Planning Conservation & Design Consultation

Consultation on Application Number: 2017/91022

Address: 9, Gill Birks, Meltham, Holmfirth, HD9 4DZ

Proposal: Erection of detached dwelling (within a Conservation Area)

Roof

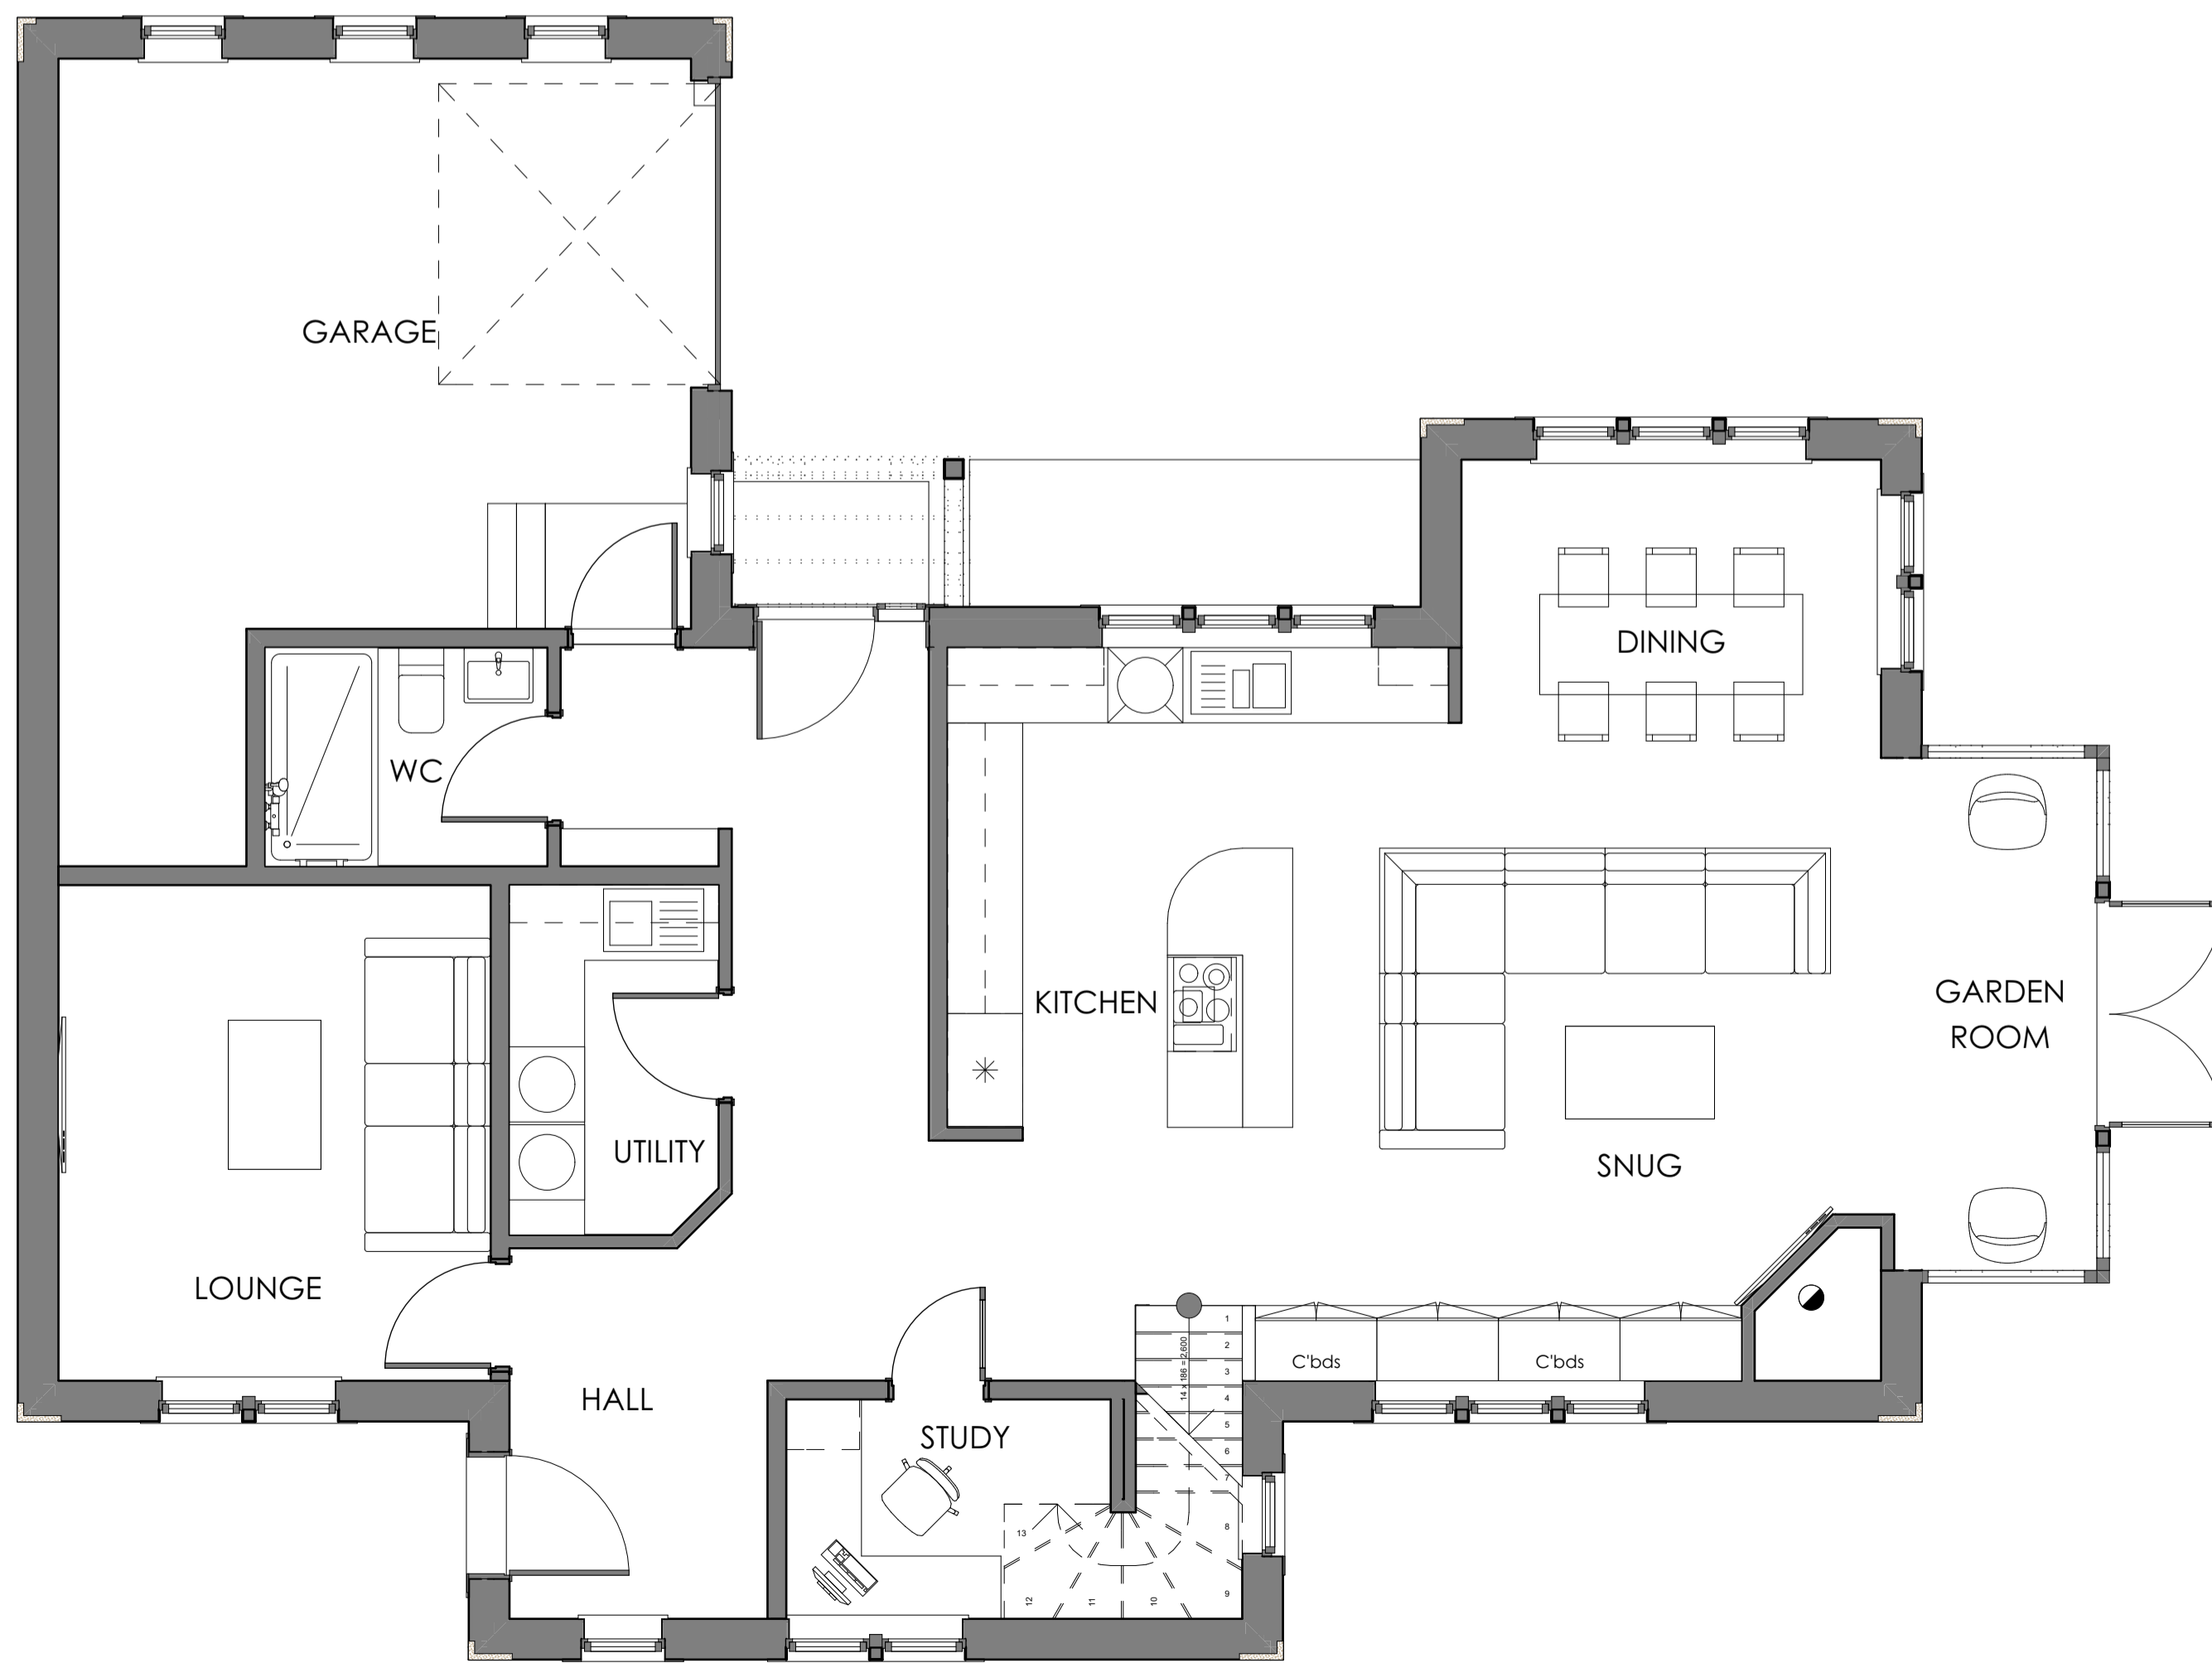
The only concern which C&D would raise concerns the provision of solar panels. The need to mitigate climate change is supported by the Conservation and Design team; however, it is important that this need does not have an adverse impact upon the neighbouring grade II listed building and the Wilshaw Conservation Area. Whilst we do not object to the use of this technology it is considered that this new development presents an excellent opportunity for it to be integral to the design as opposed to retrofitted, particularly when considering that the south roof will be read alongside the neighbouring listed building and is also the main elevation as you approach the property. Therefore we would suggest that the use of Solar Slates is considered/conditioned for use on the South & West roof slopes as a sensitive alternative.

- Windows and door frames shall be recessed a minimum of 75mm from the face of the building and so retained.
- All rooflights shall be of a conservation style and shall be installed flush with the roofline.
- South & West roof slopes shall be covered with solar slate

Project: 9 GILL BIRKS, OFF WILSHAW ROAD, MELTHAM.
 Drawing: PROPOSED ELEVATIONS.
 Client: MR & MRS BAKER.

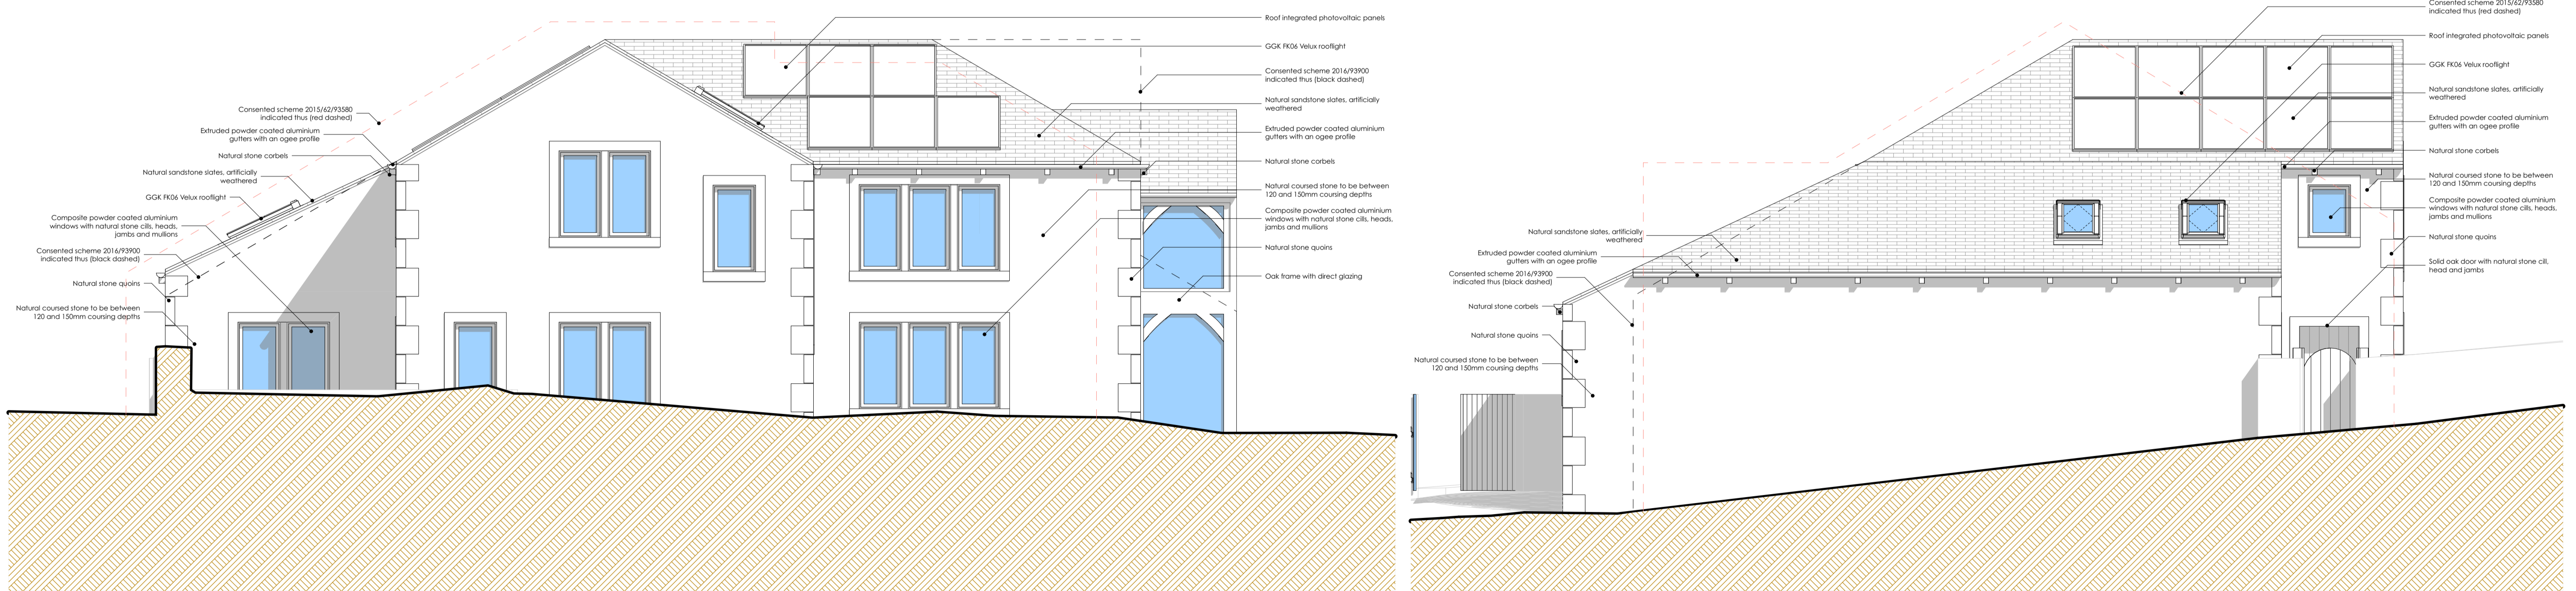
With regards to the replacement dwelling its size, scale and material palette is largely on par with the existing dwelling, however what does differ is its design. The new scheme introduces a more consistent eaves and ridge line within its design as well as reinforcing the vernacular form through the provision of a more harmonious set of traditional mullioned windows and the introduction of stone quoins and corbels. It also seeks to sensitively introduce complementary contemporary architectural features, such as the oak frame glazed within the east elevation.
